Reinforcement to the North Shropshire Electricity Distribution Network

Document Reference: 6.6.7
Environmental Statement Appendix 6.7
LVIA Scoping Opinion Responses

APPENDIX 6.7: LANDSCAPE AND VISUAL ASSESSMENT RESPONSE TO SCOPING OPINION

Document Title: CHAPTER 6: LANDSCAPE AND VISUAL FIGURE 6.4 LANDSCAPE RECEPTORS PAGE 3 OF 5

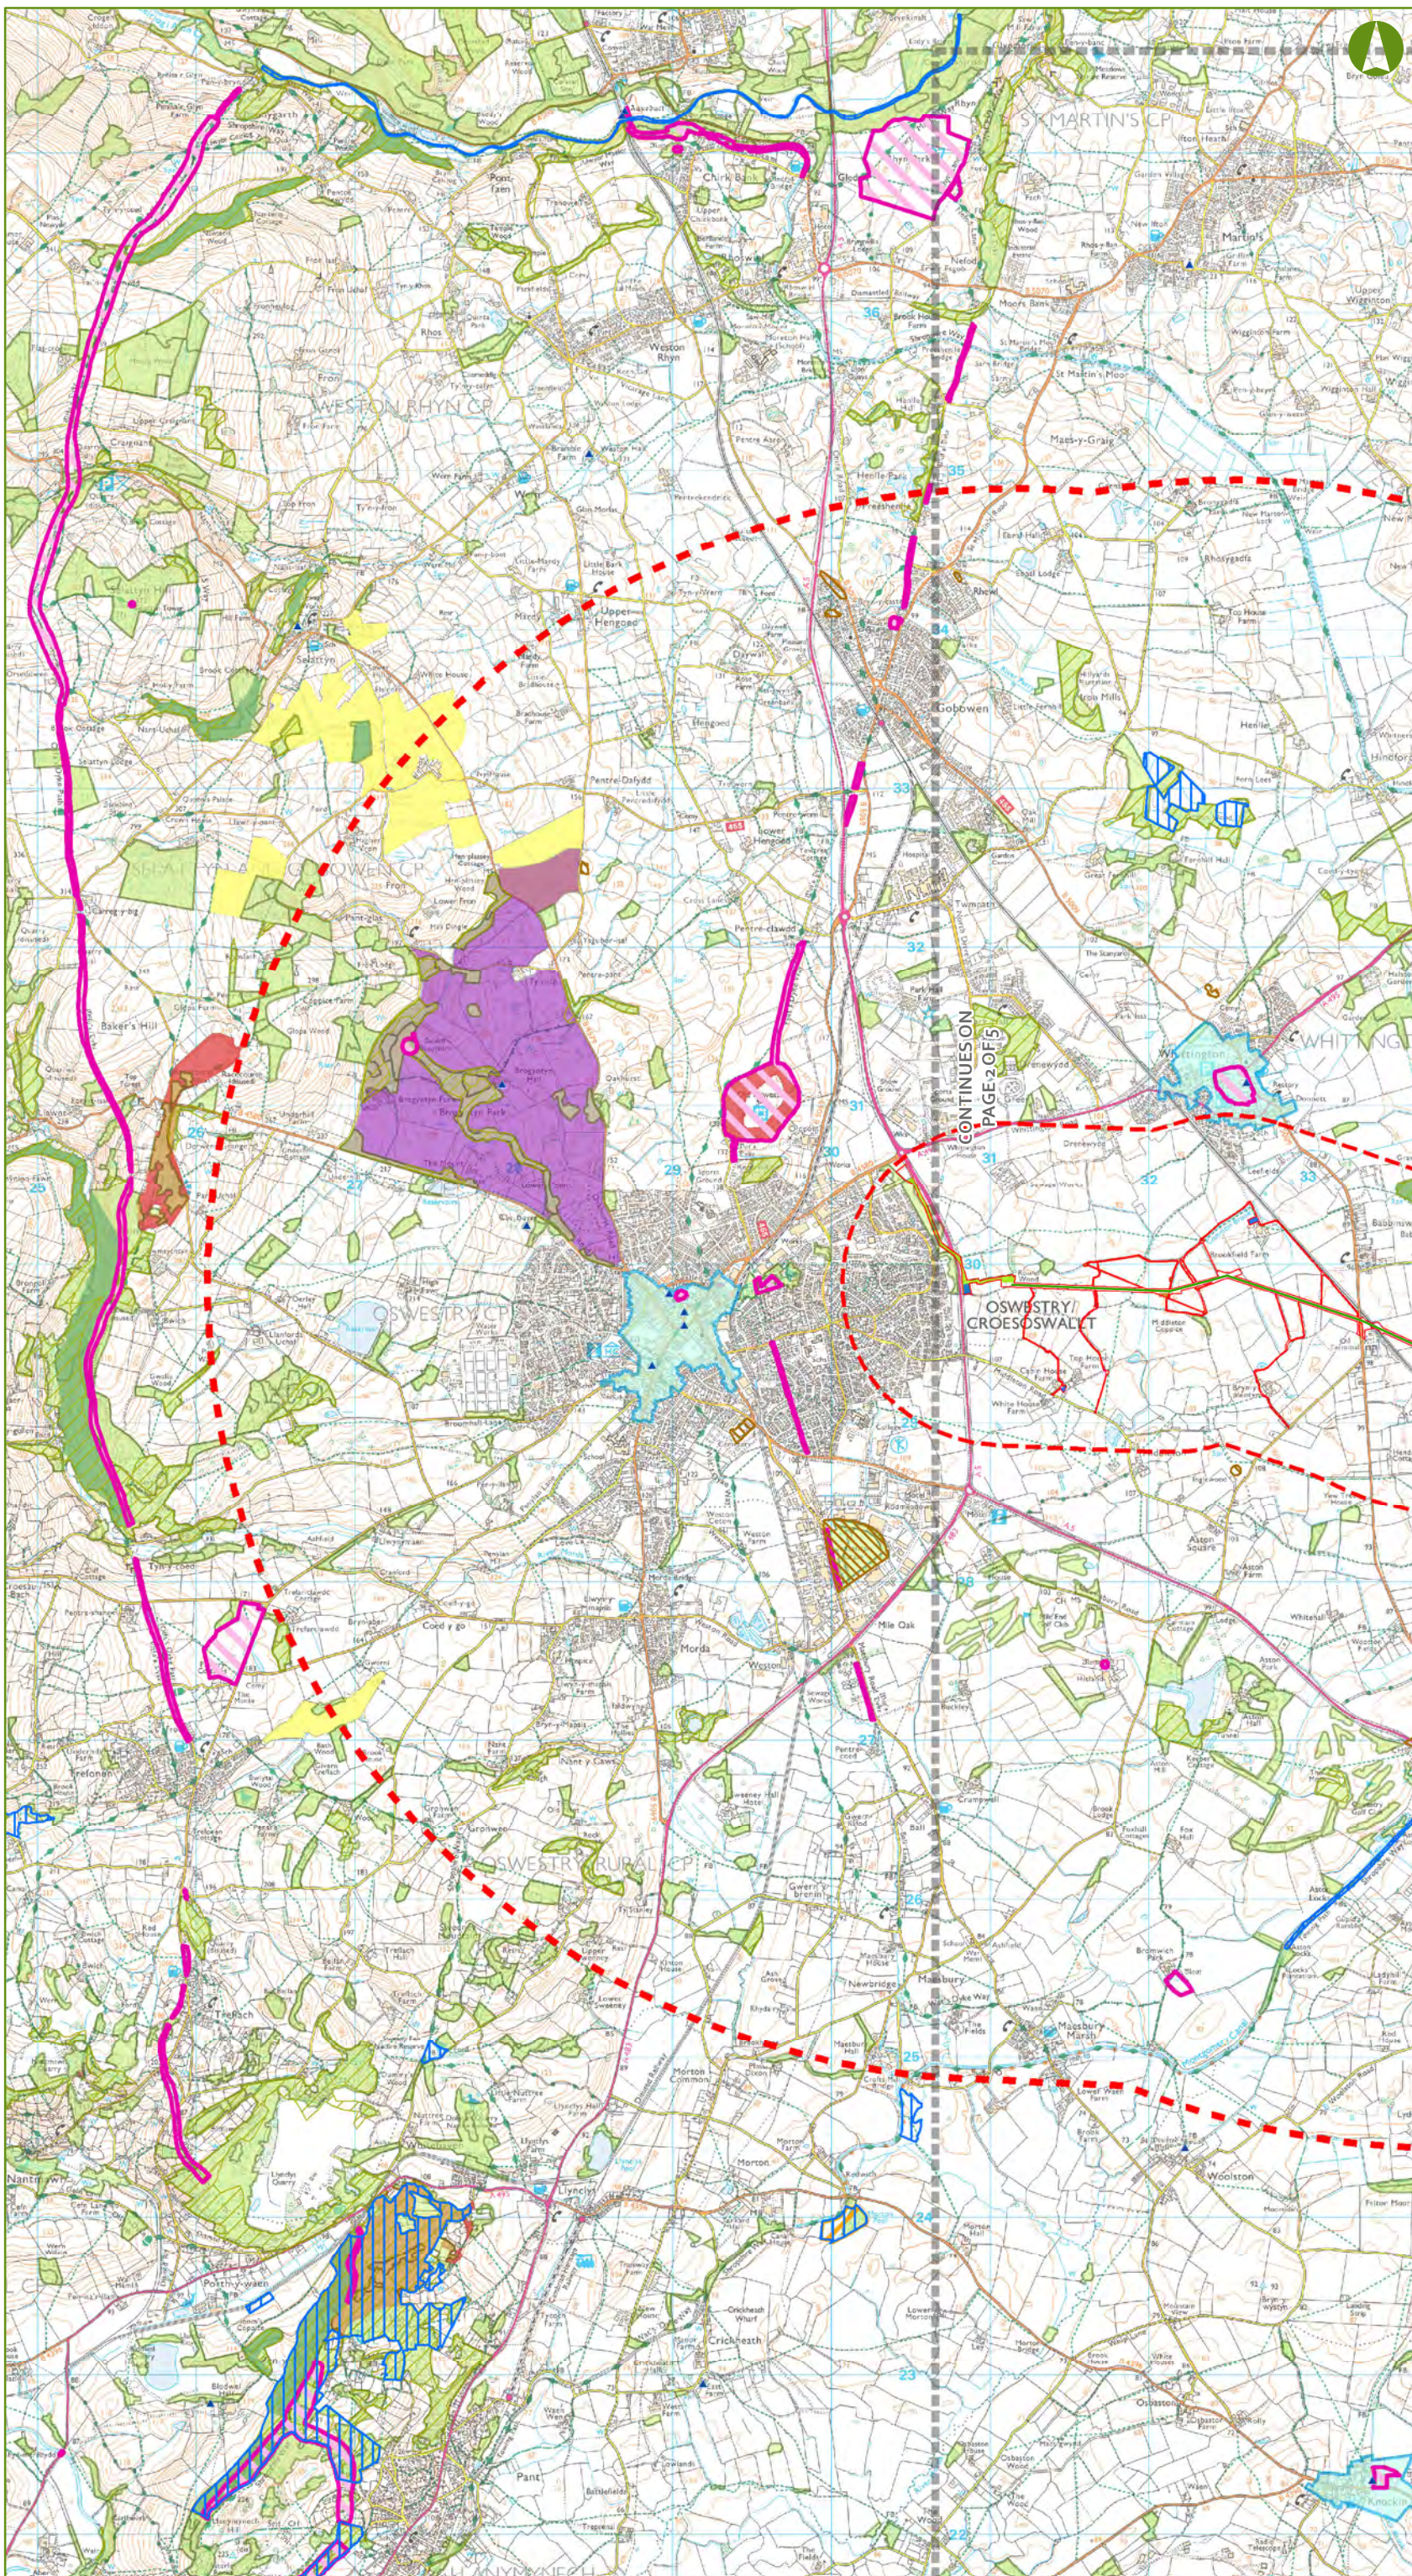
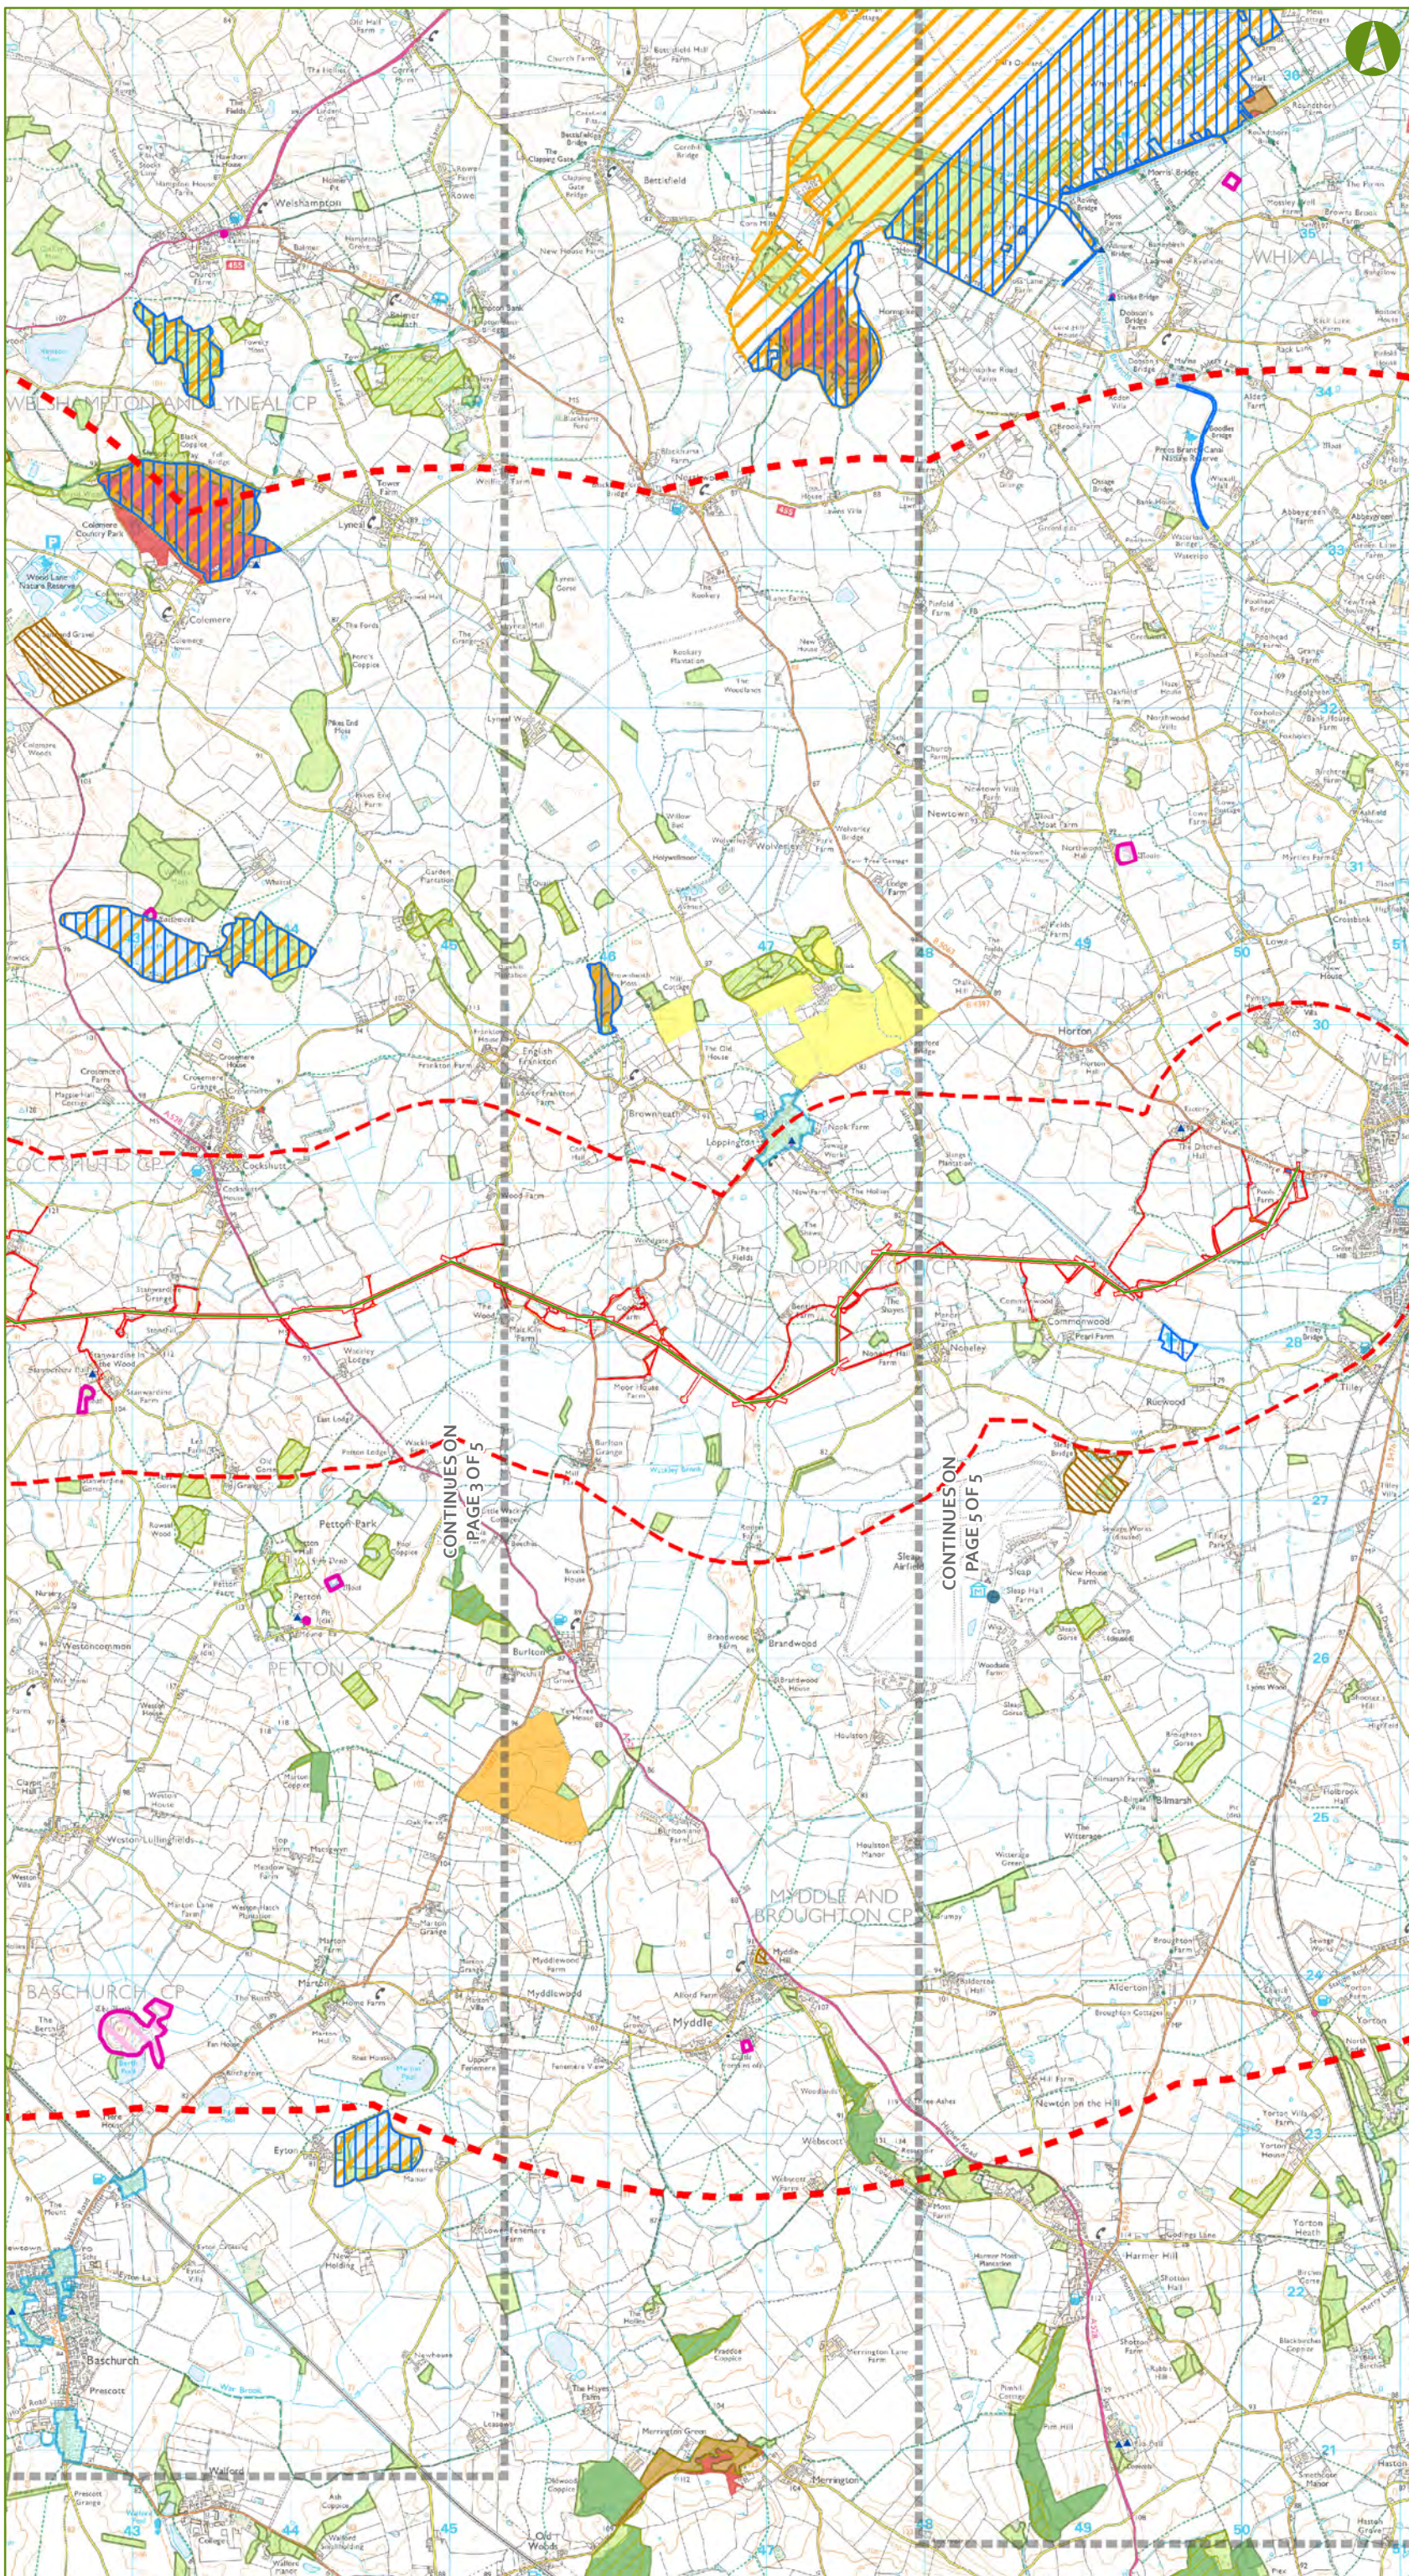
3.36	Paragraph 7.5.12 identifies a number of designated and non-designated sites. It would be helpful if this information was provided on plans in the ES to aid understanding of the features in the area that contribute to landscape character.	This information is presented within Figure 6.4 ‘Landscape Receptors’ (DCO Document 6.14) and Figure 6.6 ‘Public Rights of Way and Areas of Open Access’ (DCO Document 6.14) of the ES.
